Sydney
WATER

14 December 2010

Re: MP 10_0160 Seniors Living Development at the Scottish Hospital, 2 Cooper Street, Paddington

DRAWING TITLE
Level 01 Plan
DRAWING No
DA 202

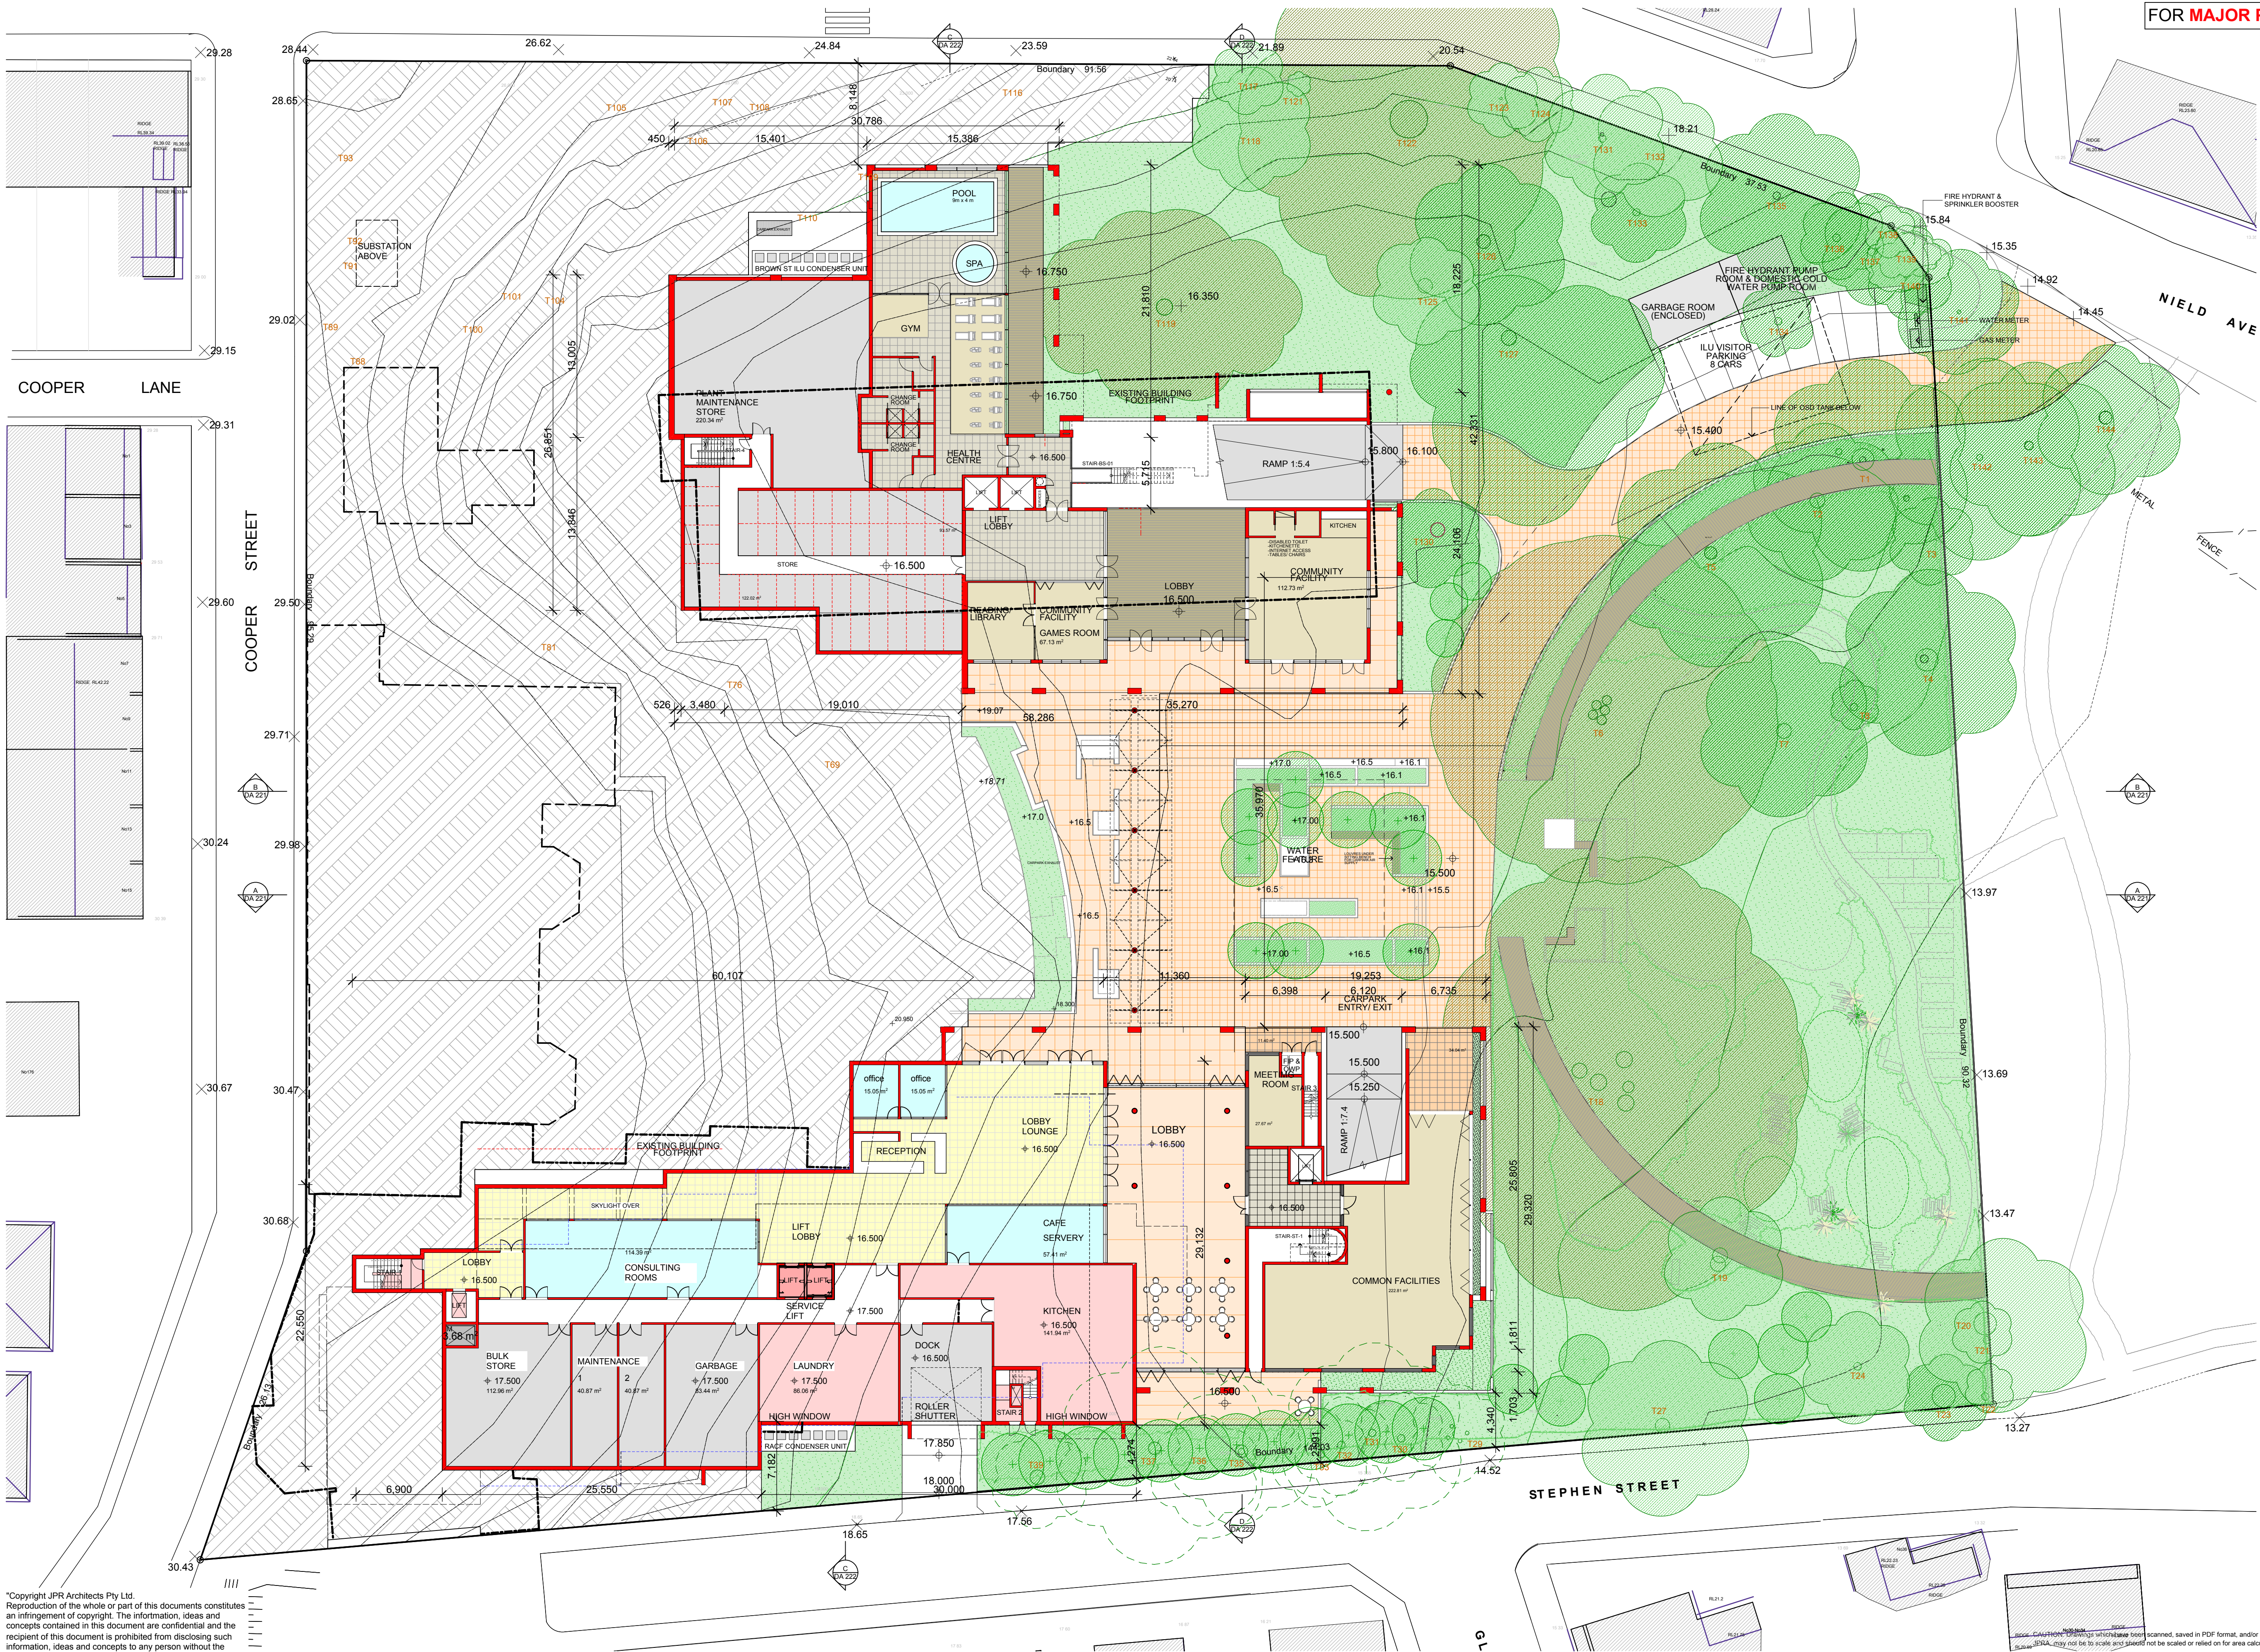
The site is located in the mid to upper section of the Rushcutters Bay stormwater drainage catchment. The site is traversed by a 900 mm stormwater conduit, which enters the site at the Stephen Street boundary and exits at the Dillon Street boundary.

Preliminary assessment shows there is a potential conflict between this stormwater conduit and the proposed Stephen Smith building. For Sydney Water to support the proposed development, we require a minimum of one metre clearance either side of the existing conduit. Detailed plans should be submitted to Sydney Water to demonstrate compliance with this requirement.

To prevent damage to Sydney Water's stormwater assets, building foundations are to be designed and certified by a structural engineer based on the following criteria:

- Buildings are to be supported on pier foundations so structural loads are not transferred to Sydney Water stormwater assets.
- Buildings must be able to remain fully supported in the event of structural failure and collapse of Sydney Water stormwater assets.
- Piers are to be bored not driven.
- Piers are to extend to at least 0.5 metres below the Zone of Influence of Sydney Water stormwater assets.
